Subject: Barnham, Eastergate, Westergate BEW Parcel SC1 Barnham - BN/11/22/OUT

Planning Application Reference: BN/11/22/OUT

Location: Barnham, Eastergate, Westergate BEW Parcel SC1 Barnham

Environmental Health has no objection in principle to the above proposal, however the following matters must be considered.

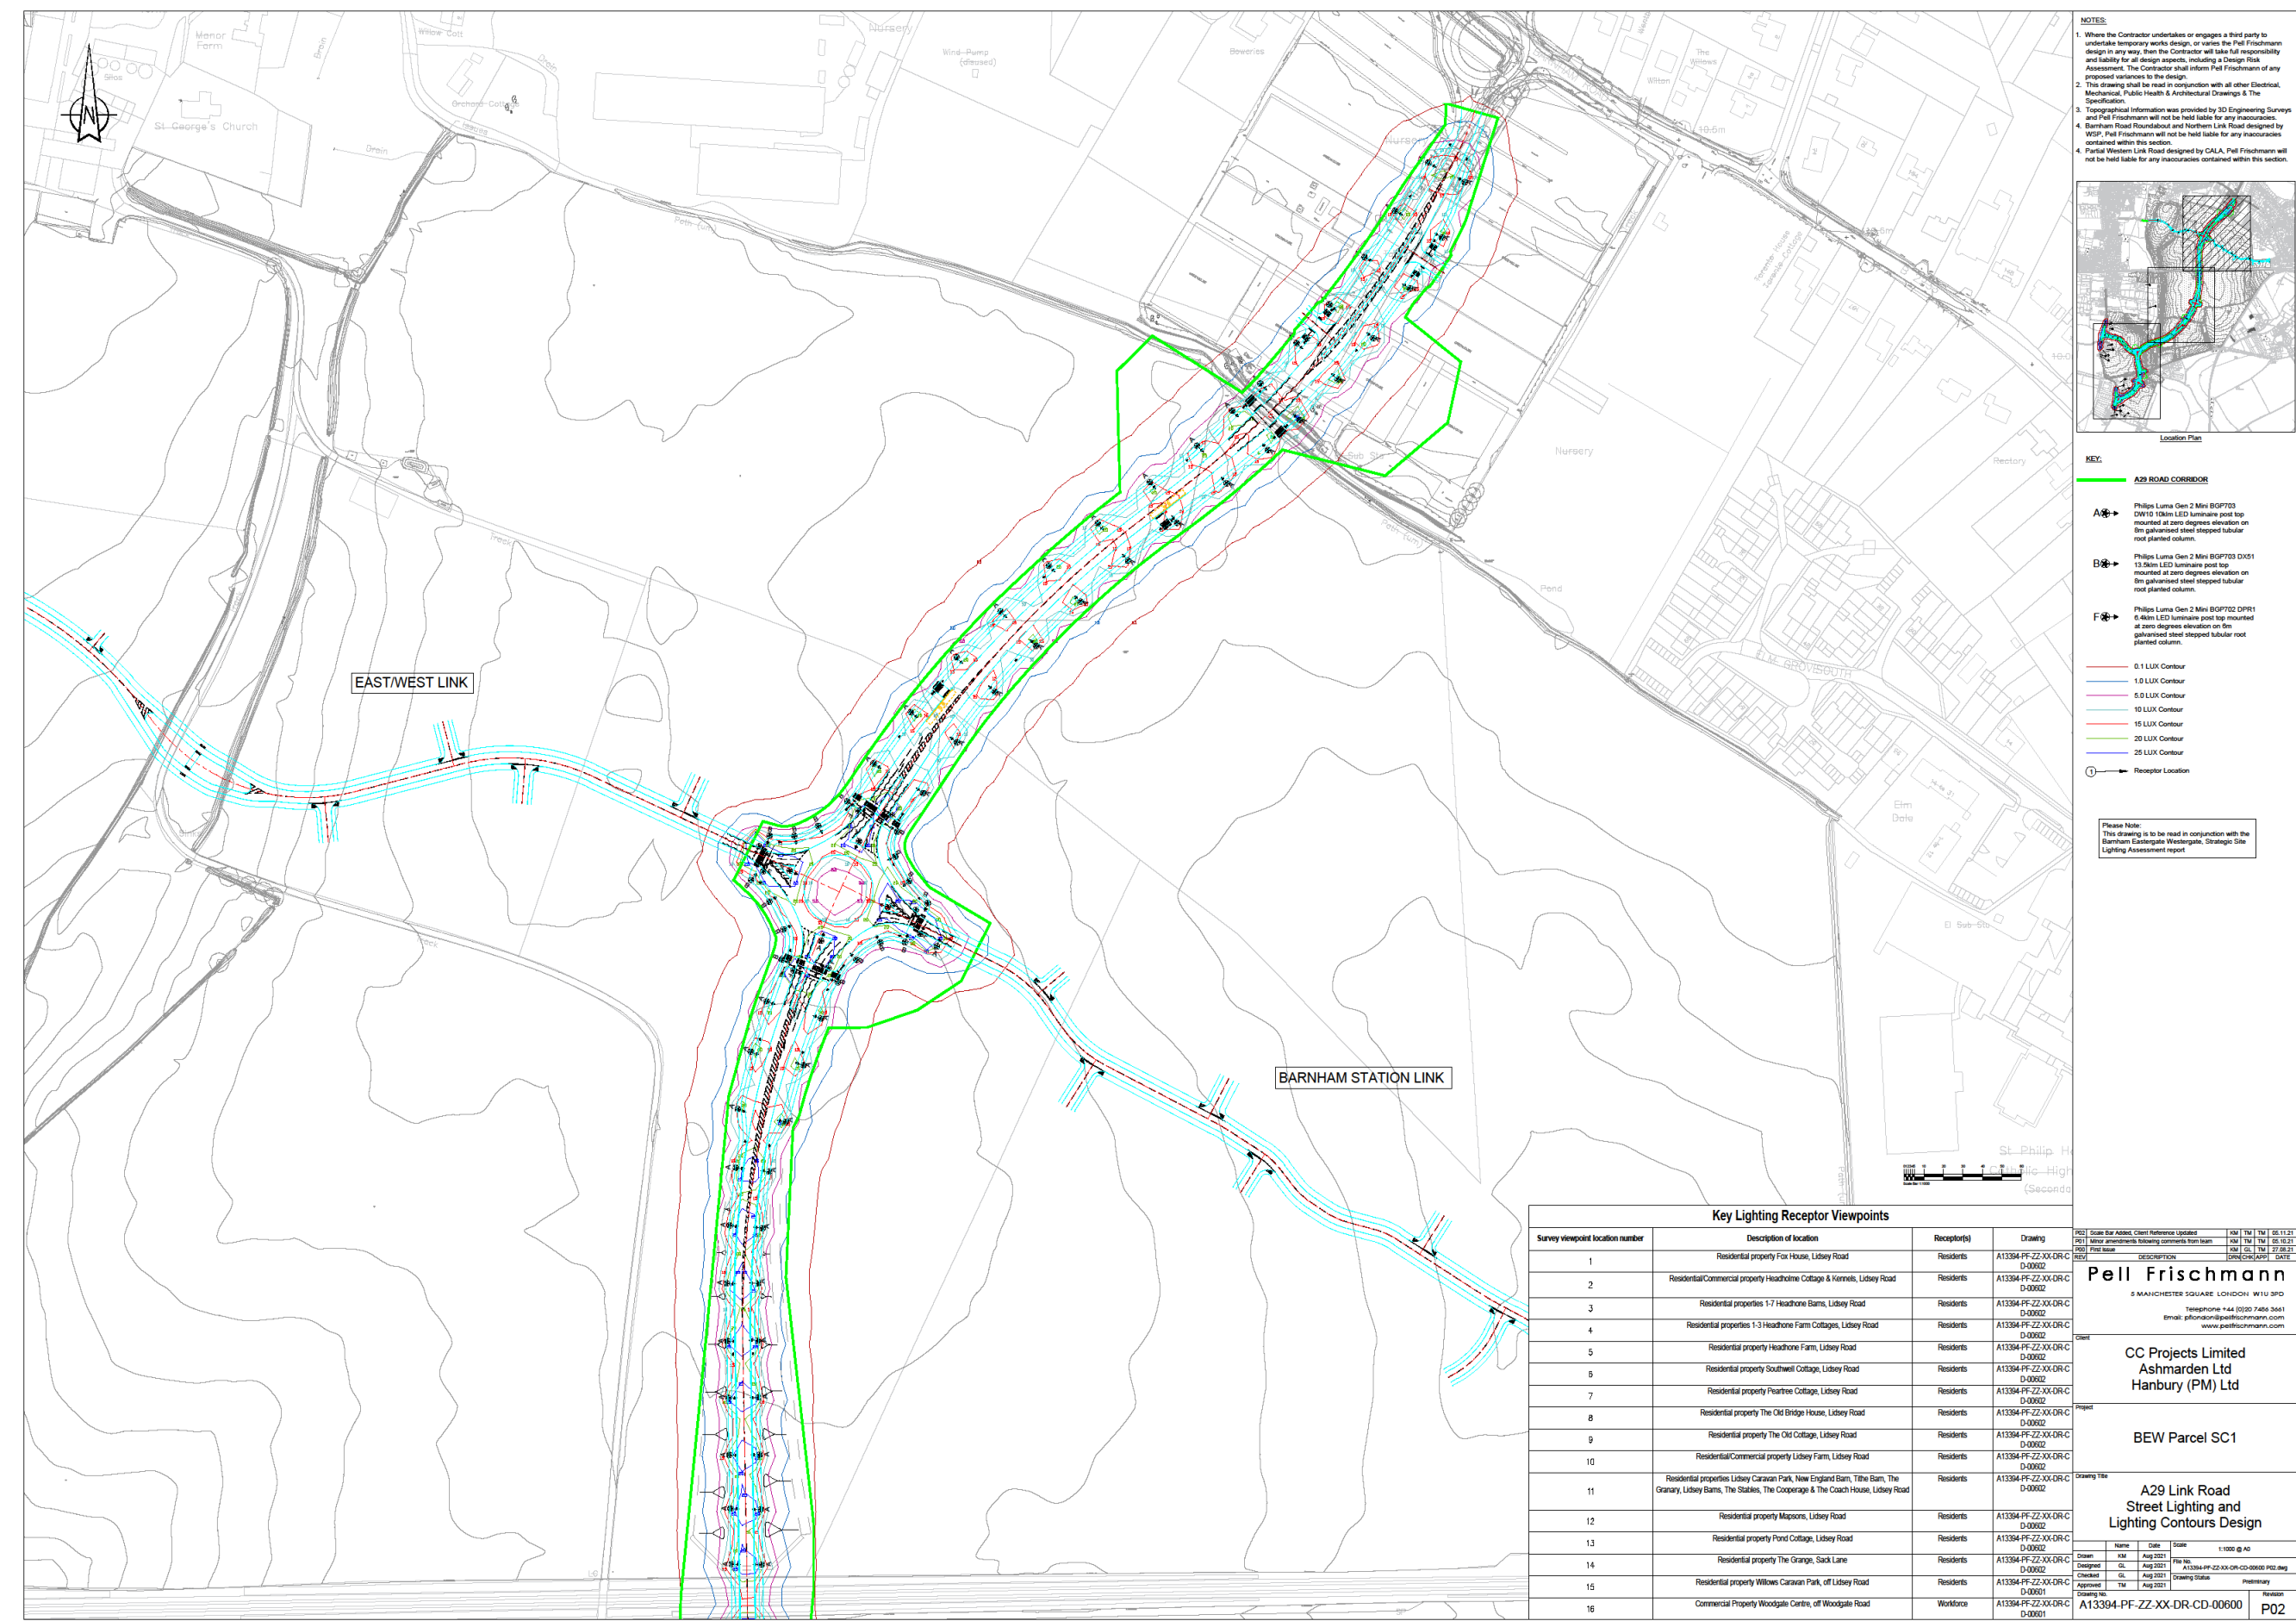
I note the applicant has provided full details for proposed external lighting regarding the A29 element of the application.

I request the applicant provide further details relating to external lighting for the residential streets included with the application.

No external lighting shall be installed until details have been submitted to and approved in writing by the Local Planning Authority prior to the commencement of the development. This submission shall include a layout plan with beam orientation and a schedule of light equipment proposed (luminaire type; mounting height; aiming angles and luminaire profiles). The approved scheme shall be installed, fully assessed by a competent individual when operational to ensure no light creep / bleed, maintained and operated in accordance with the approved details unless the Local Planning Authority gives its written consent to the variation.
